19th July, 2018

AW71/18/HH – 36 Kingsway – Conservation Area – Objection

Drawing
Arboricultural Impact Assessment,
Arboricultural Method Statement

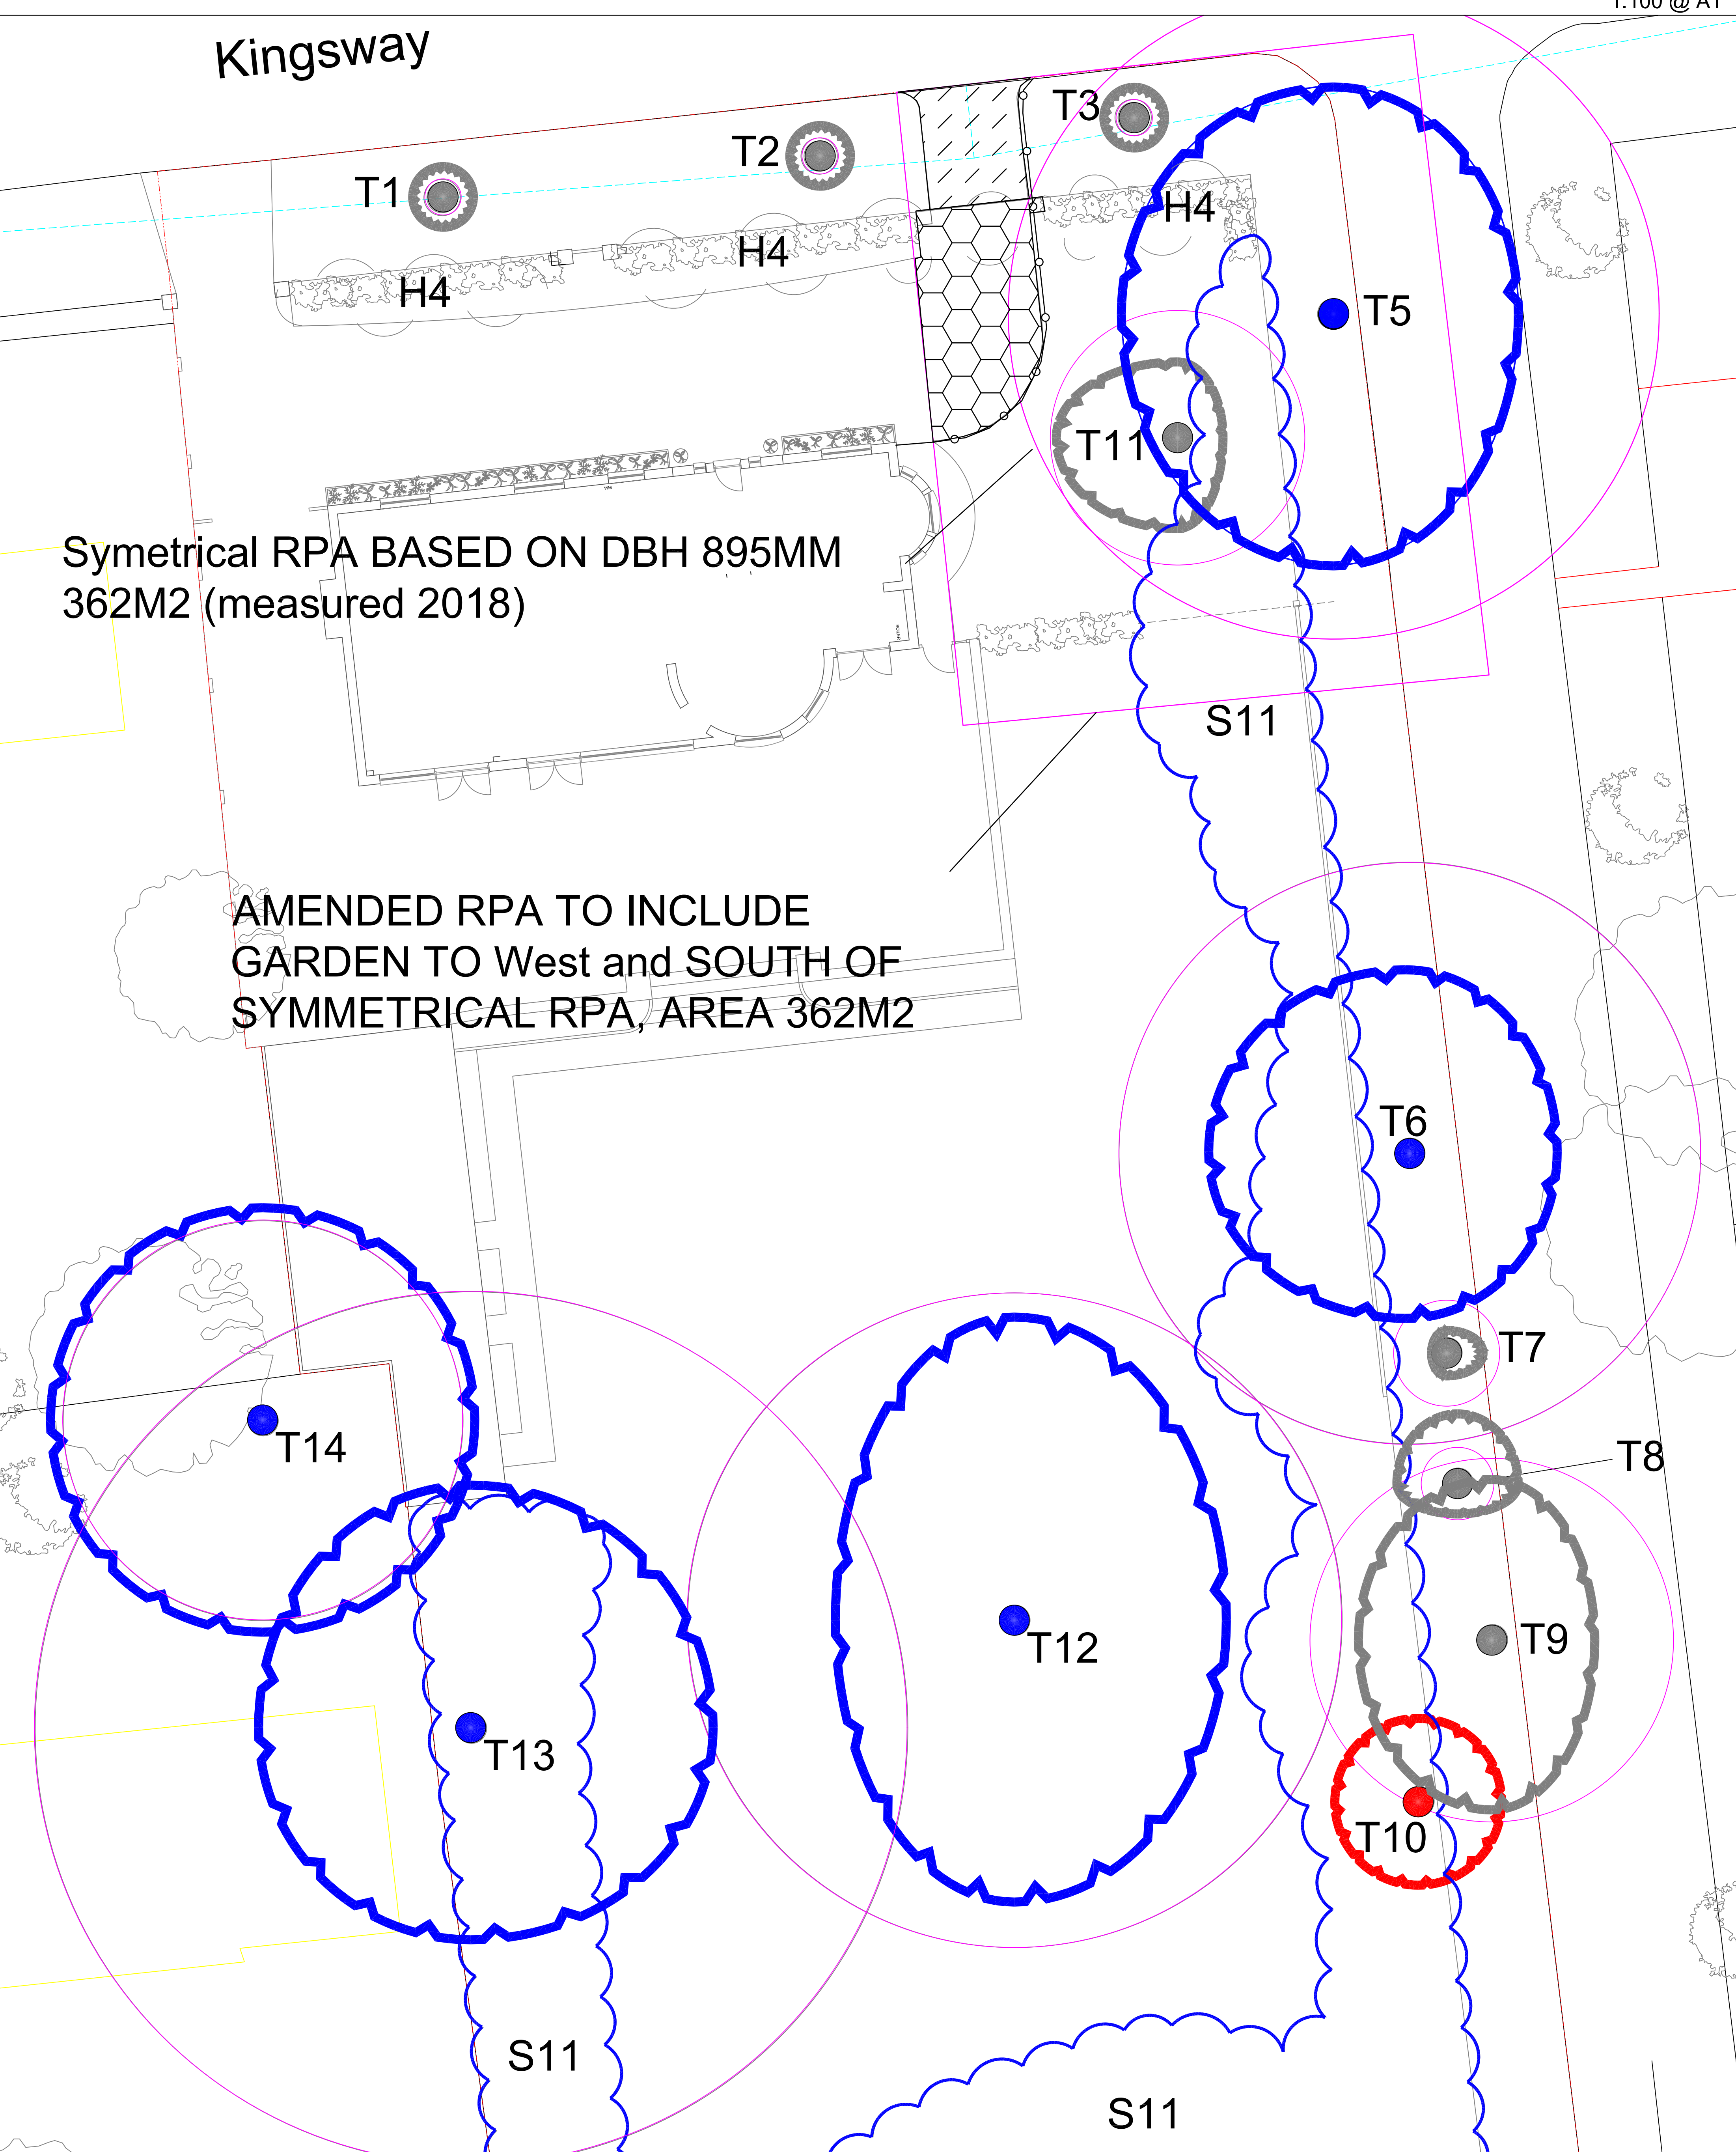
Paragraph 8.2, referring to one of the two areas within the root protection area, includes: 'The area of driveway adjacent to Kingsway will be excavated by hand to enable a dropped crossing to be constructed, the extent of the excavation will vary as it progresses towards the garden boundary where it will have reached the existing ground level.' Later in the same paragraph 'The construction will then be carried out using the principles set out in the typical construction detail shown in the Geosynthetics drawing for cell web no dig construction as illustrated in the architects drawing.'

TITLE
**Cellweb Section - Tree Root Protection
c/w Block Paving Surface**

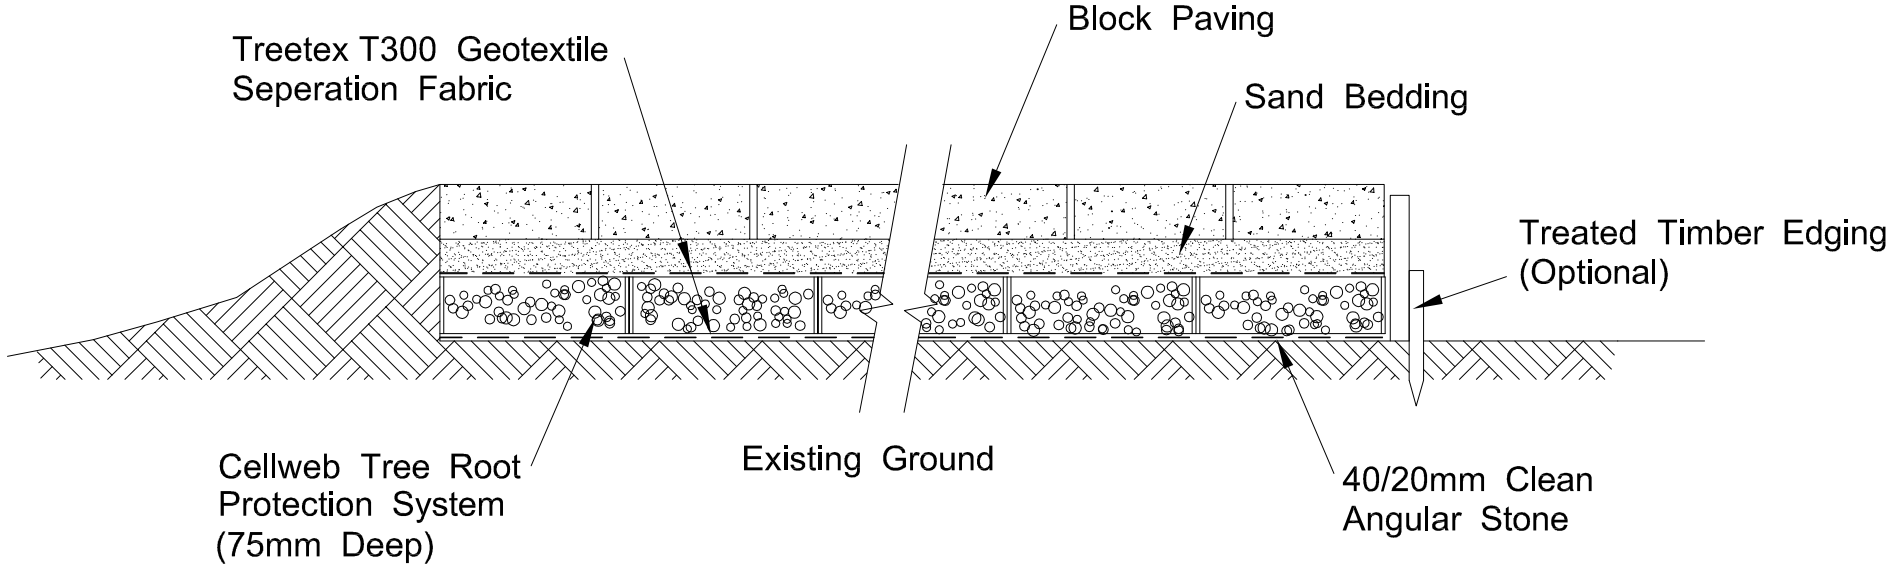
In other words the cell web construction will sit on top of a slope from about 20cms below the existing gutter to the present ground level at the Queenslawn boundary. The system, according to the drawings is 20 cm thick, so there will be a slope, across the grass verge, from the present gutter level to 20cm above the present ground level at the curtilage boundary, roughly equivalent to the top of the existing fence gravel boards.

On the eastern side this ramp is shown as vertical and supported by 20mm wooden boarding secured by vertical 15mm wooden stakes.

This must be one of the most aesthetically objectionable proposals for a conservation area – a ramp supported by wooden boards and stakes across the grass verge. The grass verges are one of the glories of this part of Kingsway and were recognised as such when Conservation Area status was granted. The proposal is clearly aesthetically unacceptable.

Also one wonders about the stability of such a structure with traffic passing over it. It looks extraordinarily flimsy.

Do you envisage the need for railings to prevent the postman or anyone else from either tripping over the ramp or falling off it?

Will the excavations below the gutter have any effect on the road foundations?
